Submission No.			181	
Organisation Name or Name of Submitter			Senator Marie Sherlock	
Item No.	Section Ref.	Page No.	Observation Statement	TII Response
Letter Re: MetroLink Railway Order Application submission REF - 314724				
1	1 Construction Management:	1	Construction of the three stations which are planned for Dublin 9 and 7 will have enormous impacts on the traffic flows in the area. Traffic management plans must be published, and consultation must take place with the local communities well in advance of any works commencing	<p>Chapter 5 of the EIAR, MetroLink Construction Phase, explains that traffic management plans for the construction phase of the Project have been developed to minimise the impact on road users, and to maintain access to property. Prior to implementation, all traffic management measures will be agreed with DCC and where relevant, consultation with An Garda Síochána and other statutory stakeholders will be undertaken. The design of traffic management measures and highways works is based on achieving the key objective of maintaining continual access to all properties during the works. Where necessary, a safe alternative route will be provided for pedestrians

Arboricultural Impact
Griffith Park
96 of 108

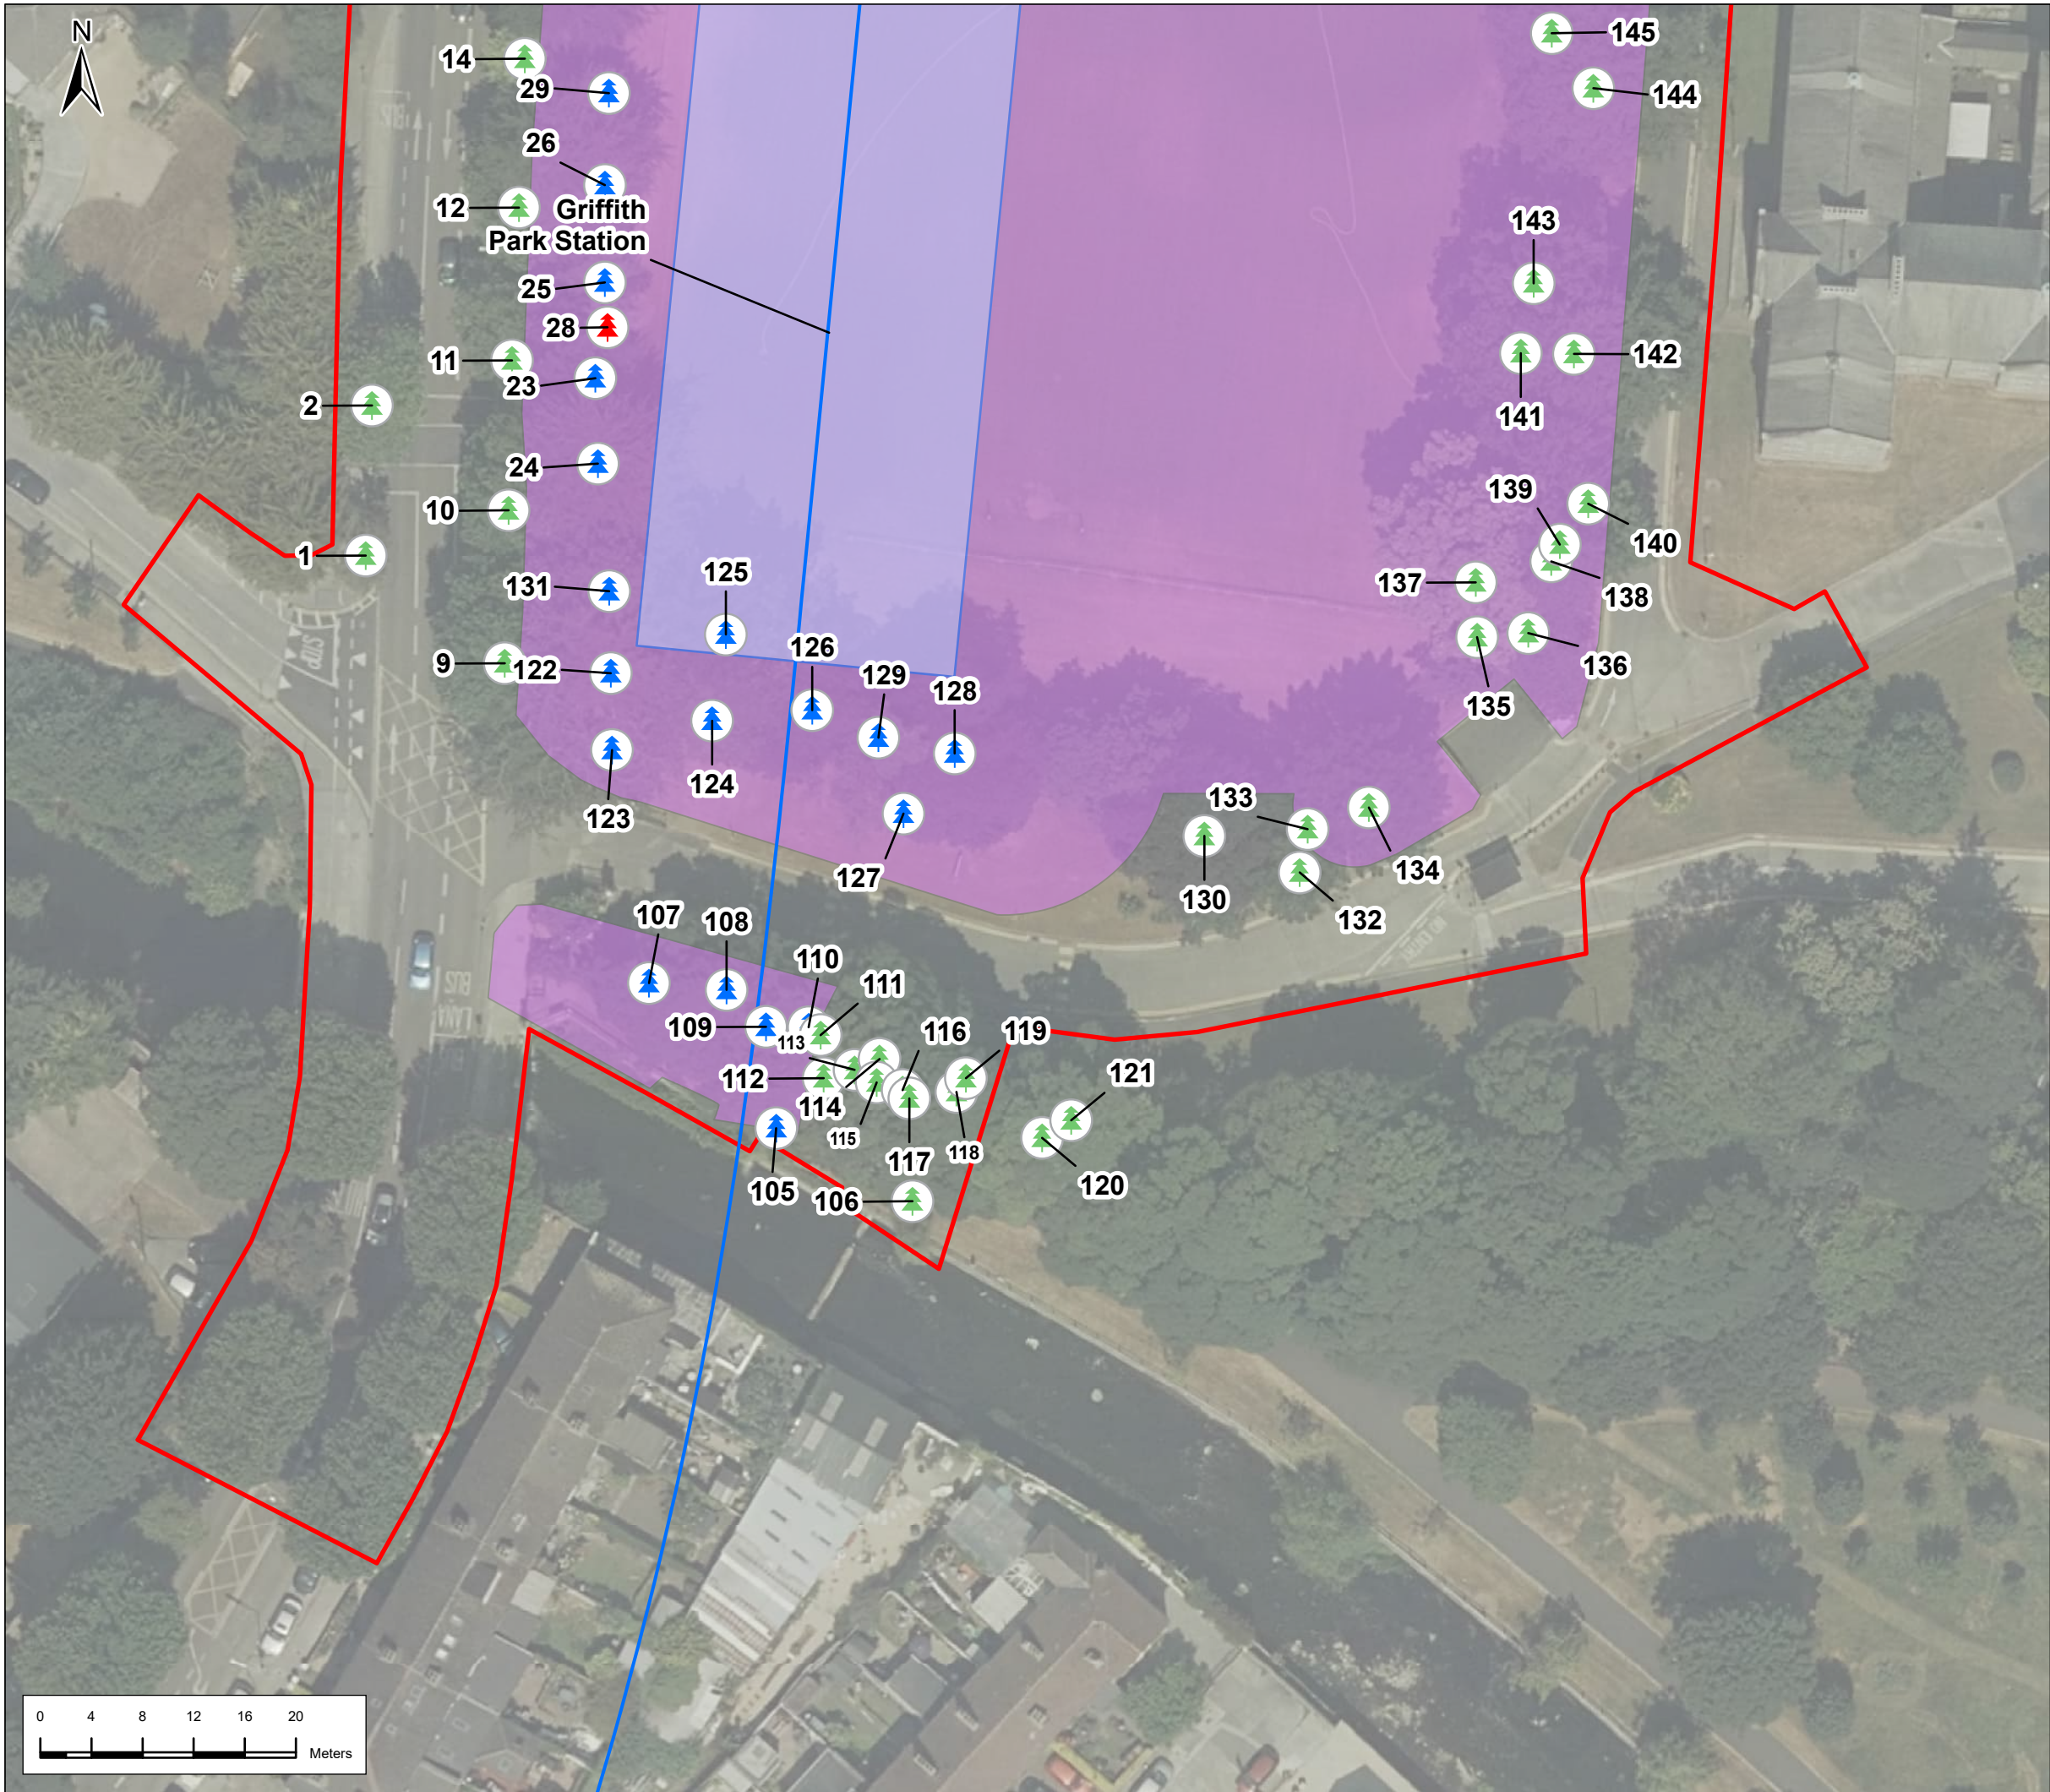
3	1.2 Griffith Park Station	1	Local residents will also need a very clear picture of the traffic management system here, given such high levels of heavy plant and machinery that will be in the area on a daily basis over an extended period.	<p>Please refer to response (1) above. TII will implement signage strategies for access traffic and through traffic, the public will be provided with advanced warning of any proposed diversions and disruption, and there will be continuous updates on construction progress on the project website and through various social media outlets. These measures, and others, are detailed in EIAR Appendix A 9.5 Scheme Traffic Management Plan.</p>
4	1.3 Mater Station	1	Along with the problems associated with construction traffic, there is also a very significant concern here about parking in the area, this and other issues will need to be considered in advance of construction.	<p>TII confirm that parking has been considered as part the MetroLink environmental impact assessment. TII will work with the local community to mitigate so far as is reasonably practicable impacts on parking. EIAR Appendix A9.5, Scheme Traffic Management Plan, section 7.7, assesses that there will be a moderate impact to designated on-street parking due to the removal of parking bays on Eccles Street and Berkley Road. TII will seek to ensure parking bays are not used by construction staff and operatives by implementing the Construction Mobility Plan to ensure that numbers of employee vehicles travelling to and from construction sites on a daily basis will be managed through transporting workers to site via buses/mini-buses from designated collection points (such as Luas and DART stations or other appropriate locations).The full list of Mitigation Measures in the Construction Phase are summarised in EIAR Chapter 9, Traffic &amp; Transport, Table 9.147.</p>
